**RE: SSD 10376 Sydney Metro Pitt Street (South) Over the Station Development
– Stage 2 and SSD 8876 MOD 2**

I live in the Princeton apartments and want to OBJECT to the above mentioned development applications for the following reasons:

**Figure 25 | Building separation distances (in mm) between proposed building and Princeton Apartments (Base source: RTS)**

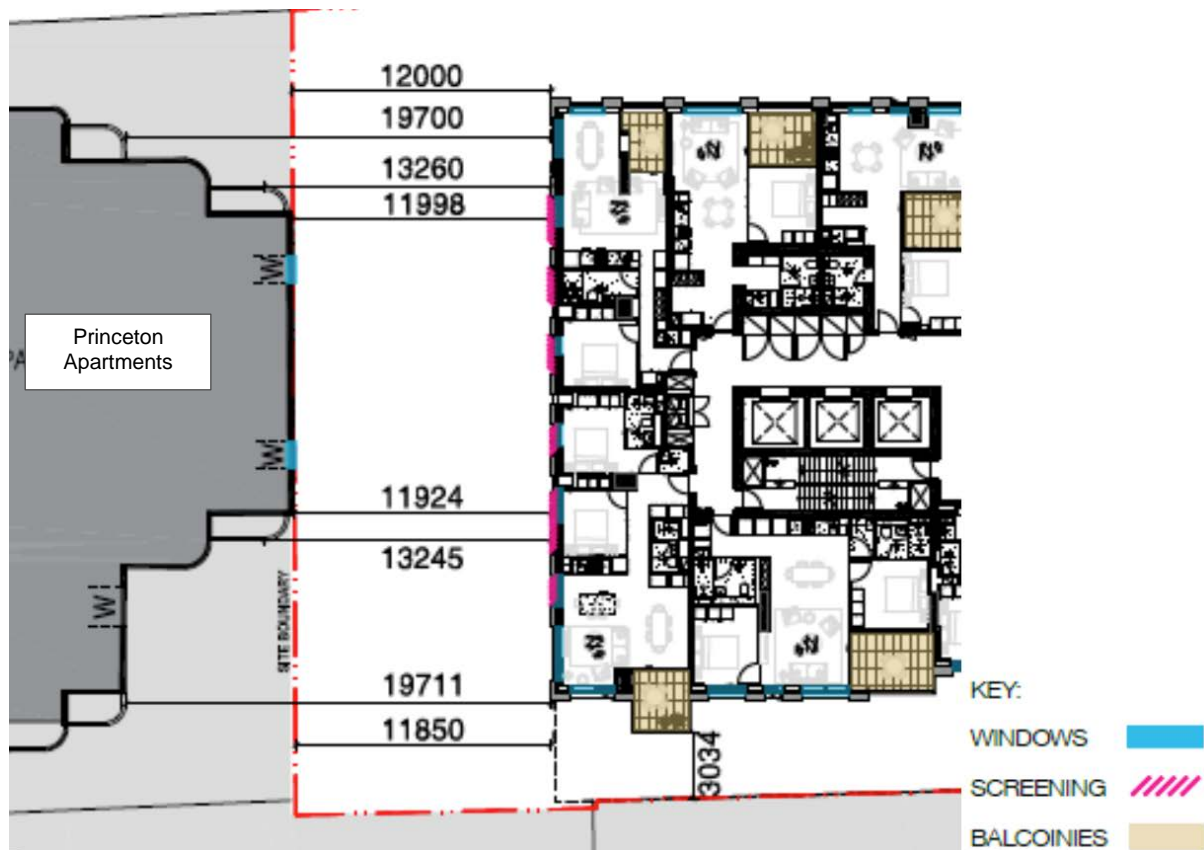
- The new building to going to exceed the maximum envelope previously approved so that they get more floor area. This will also make the building closer than the minimum 12 metres which is already having big impacts on our sun access and privacy.

- The limited separation also will have impact of our privacy and again breaches the SEPP 65 and Apartment Design Guideline. The separation of buildings should be 24 metres when having habitable to habitable room over a height of 25 metres. 11.5 metres is clearly not enough and is the reason for lost sun light to our living areas.

**Figure 30** | The submitted solar analysis identified that windows on Princeton Apartment receiving full sun at 10 am mid winter (Source: Applicant's solar analysis – 17/12/2020)

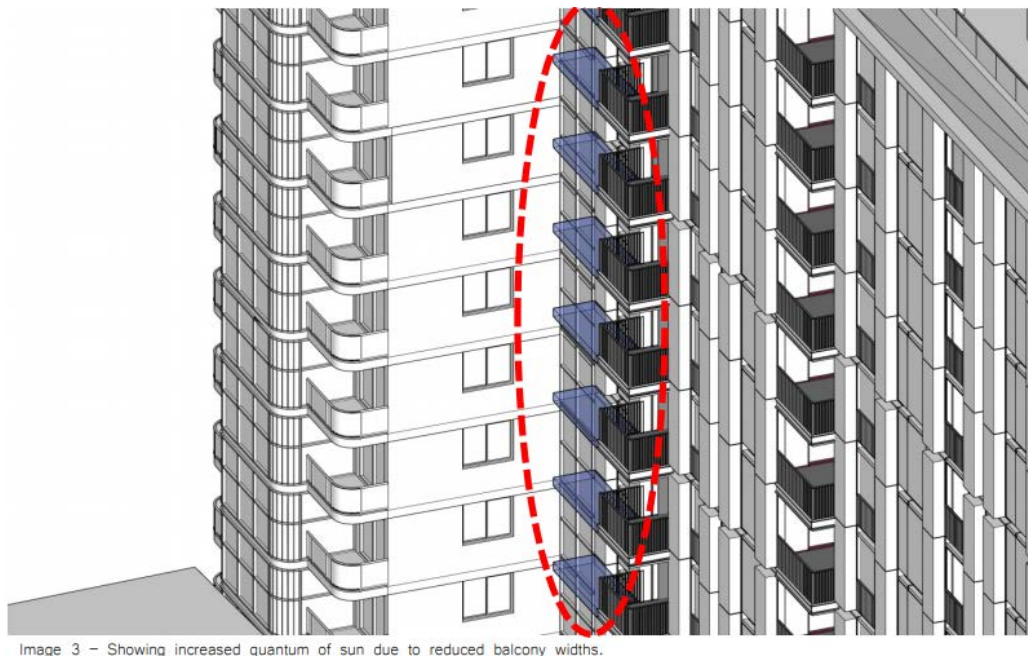
- The new building will reduce solar access to living areas at Princeton apartments as at 21st June from 54 of 116 to 6 apartments out of 116. This is a large impact and the developer has not even tried to reduce the loss of sun light to our living rooms even though the SSD 8876 consent said that new development was to maximise solar access to Princeton apartments and also comply with the Apartment Design Guidelines. The developer has made no attempt to maximise solar access and comply with the Apartment Design Guidelines.
